# STAFF RECOMMENDATION

PROJECT INFORMATION										
<b>Project Title</b>	Dell's Nursery Rezone			<b>Date of Report</b>	September 19, 2023					
<b>File Number</b>	PA 22041			<b>Attachments</b>	See Section 3.0 for links to Exhibits					
<b>Administrative Recommendation</b>	Approve the preliminary Commercial Site Plan and Concurrent Rezone from Medium Density, Single-family (R-4.5) to General Commercial (GC) in order to construct two single story office/warehouse buildings totaling approximately 30,600 SF.									
BACKGROUND SUMMARY										
<b>Applicant</b>	104 <sup>th</sup> Street LLC									
<b>Request</b>	The applicant is requesting Site Plan Approval and Concurrent Rezone from Medium Density, Single-family (R-4.5) to General Commercial (GC) in order to construct two single story office/warehouse buildings totaling approximately 30,600 SF.									
<b>SEPA Status</b>	A SEPA Mitigated Determination of Non-Significance was issued on July 21, 2023. The appeal period expired August 4, 2023; no appeals were filed.

A PORTION OF SECTION 16, TOWNSHIP 30 NORTH, RANGE 05 EAST, W.M.

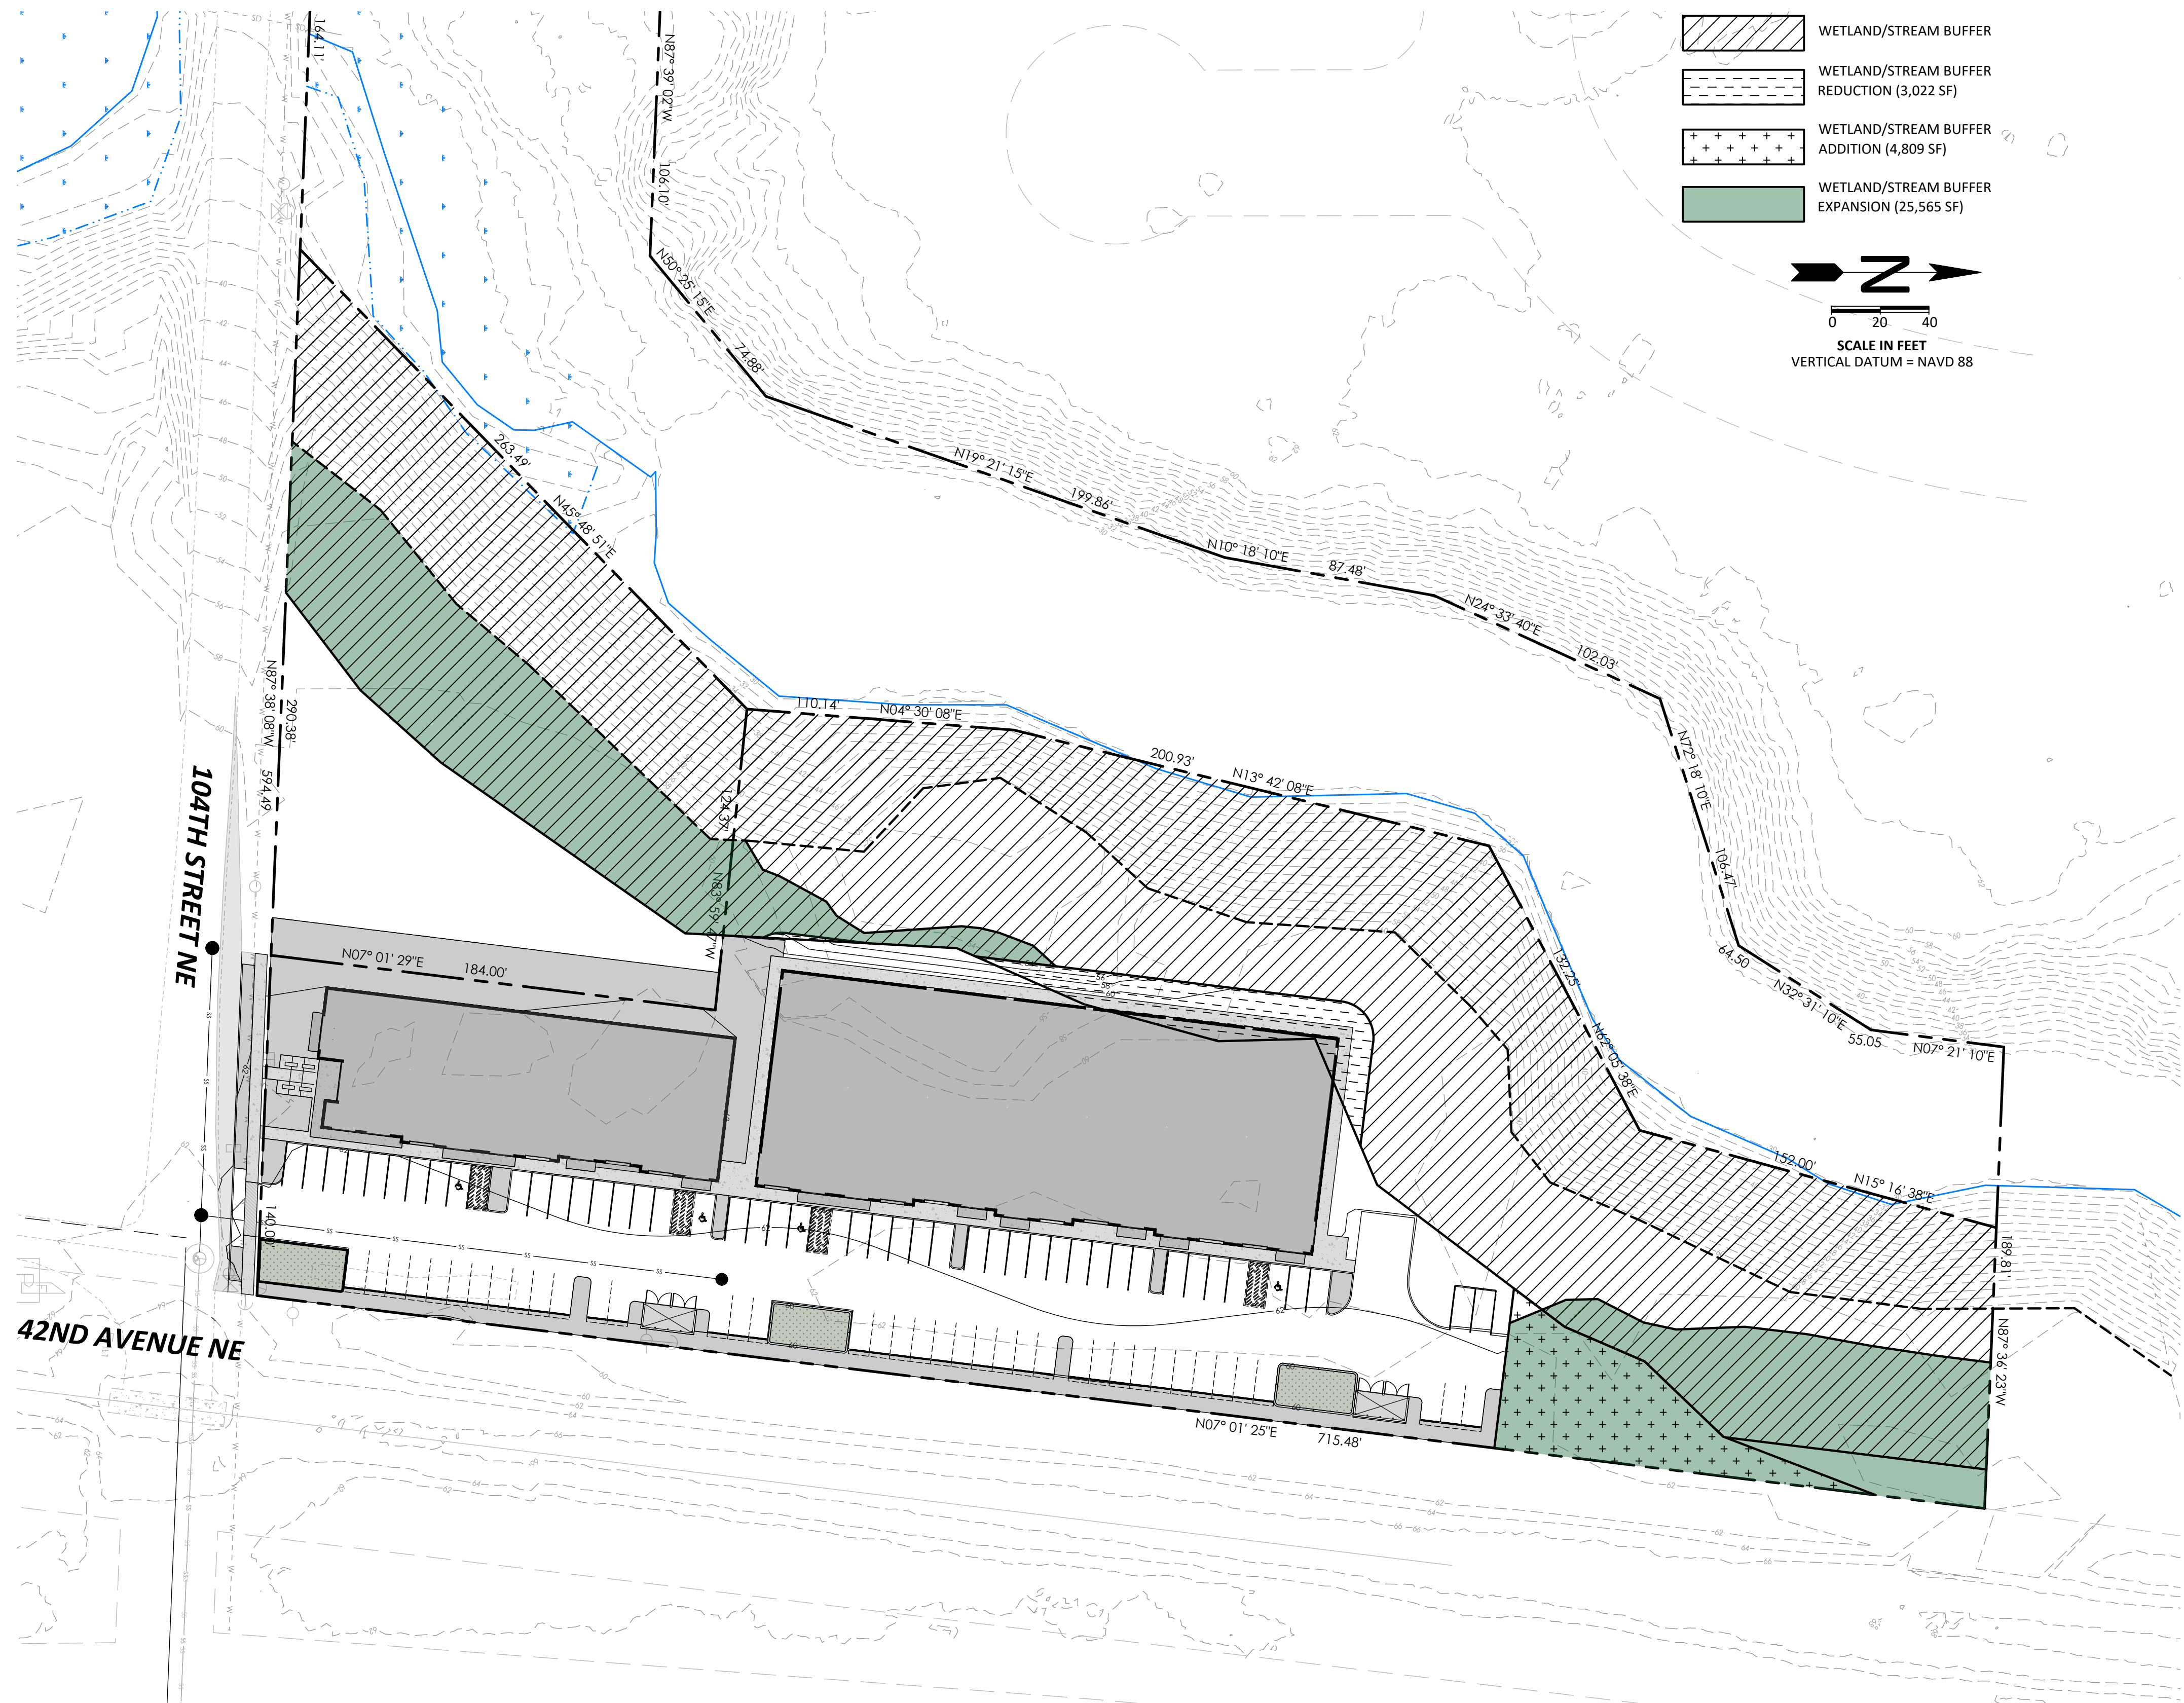
I am not happy about a huge warehouse going in as well, noting that there is a wetland buffer removal of 3,000sf.

The applicant has proposed buffer averaging pursuant to [MMC 22E.010.100\(5\)\(a\)](#) (also see Section 8 Critical Areas below). As compensation for the removal of 3,022 of the required 100 foot Category II wetland buffer, an additional 4,809 SF of buffer is proposed to be added. A final buffer mitigation plan will be required to be prepared and approved by the Community Development Department, prior to any construction activity on-site, whether the rezone is approved or if future residential development were to occur on-site.
